Ref No: F2019/00387

Re: SSD 10285 – Royal Randwick Racecourse – Leger Lawn Development

Thank you for the opportunity to comment on the Response to Submissions (RtS) report and supporting documentation prepared on behalf of the Australian Turf Club for the Leger Lawn Development (SSD 10285). Council officers have reviewed the material and provide the following advice:

SSDA-301

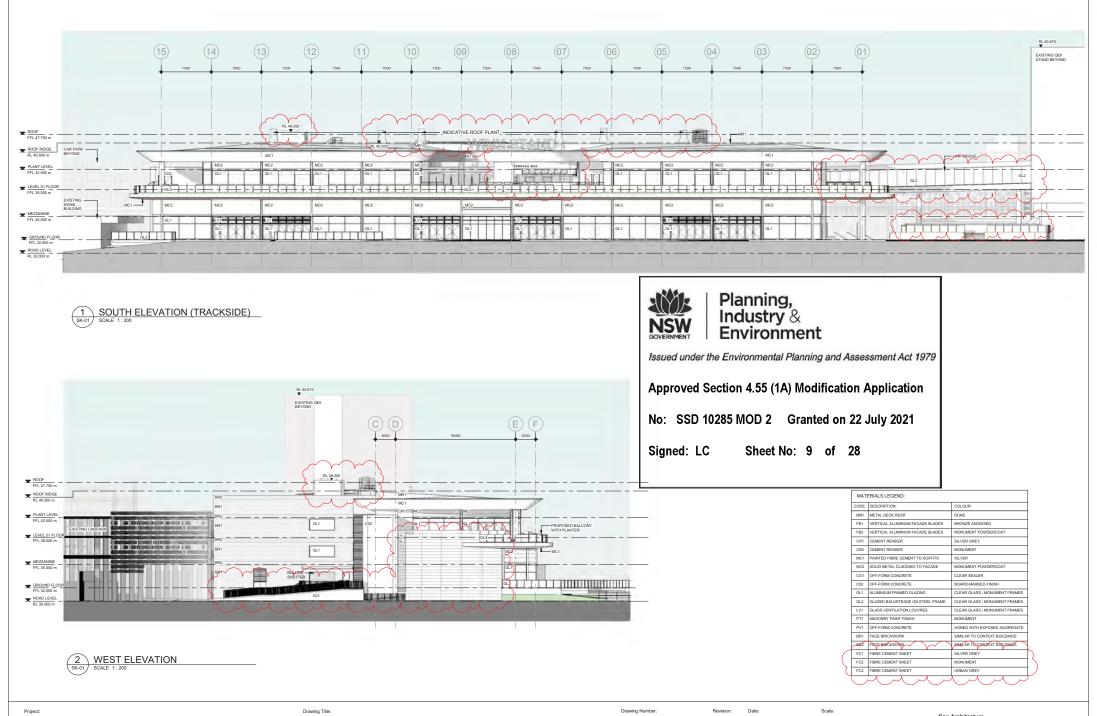
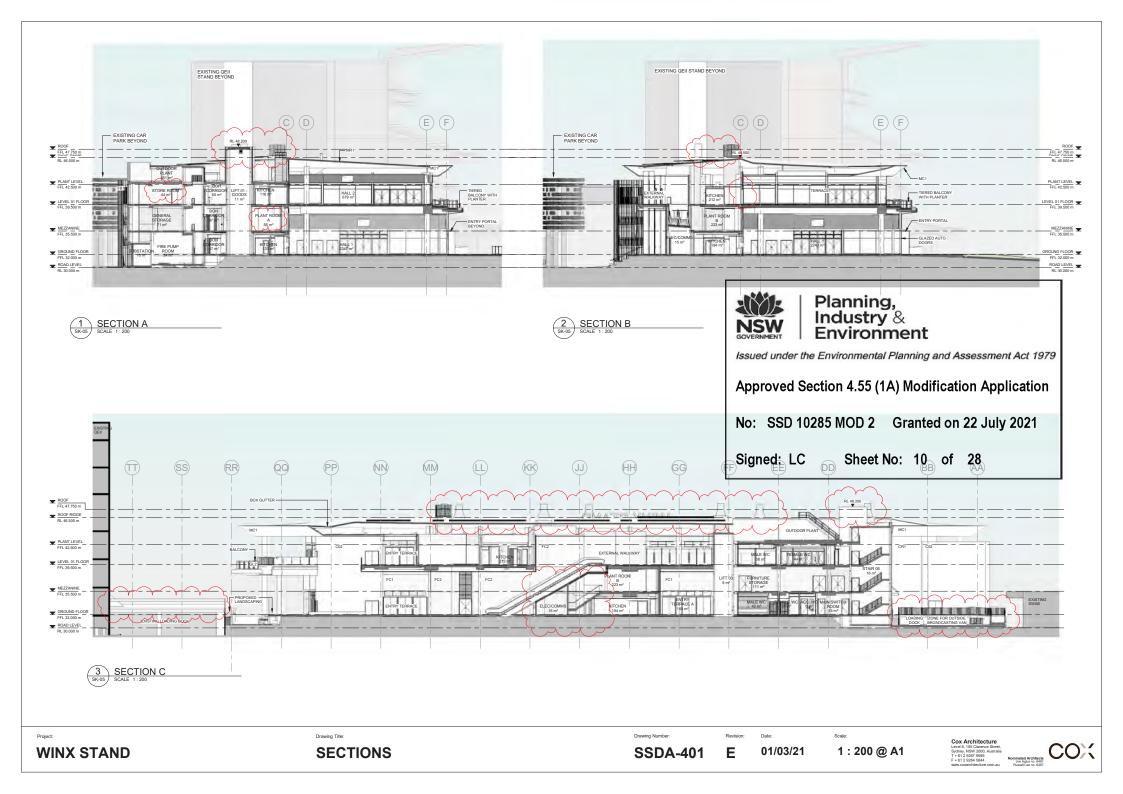
Based on this advice, the Revised Architectural Plans indicates no additional screening measures in the laneway adjacent to the back-of-house area. It is recommend that to soften and screen the visual impact of this back of house area, including the loading dock, an additional tree should be provided on the south-western side of the stairwell adjacent to the sub-station at Grid DD in drawings No. SSDA-201 Revision C (Ground Floor) and No. SSDA-301 Revision B (North Elevation (Laneway)). This is indicated in the following montage:
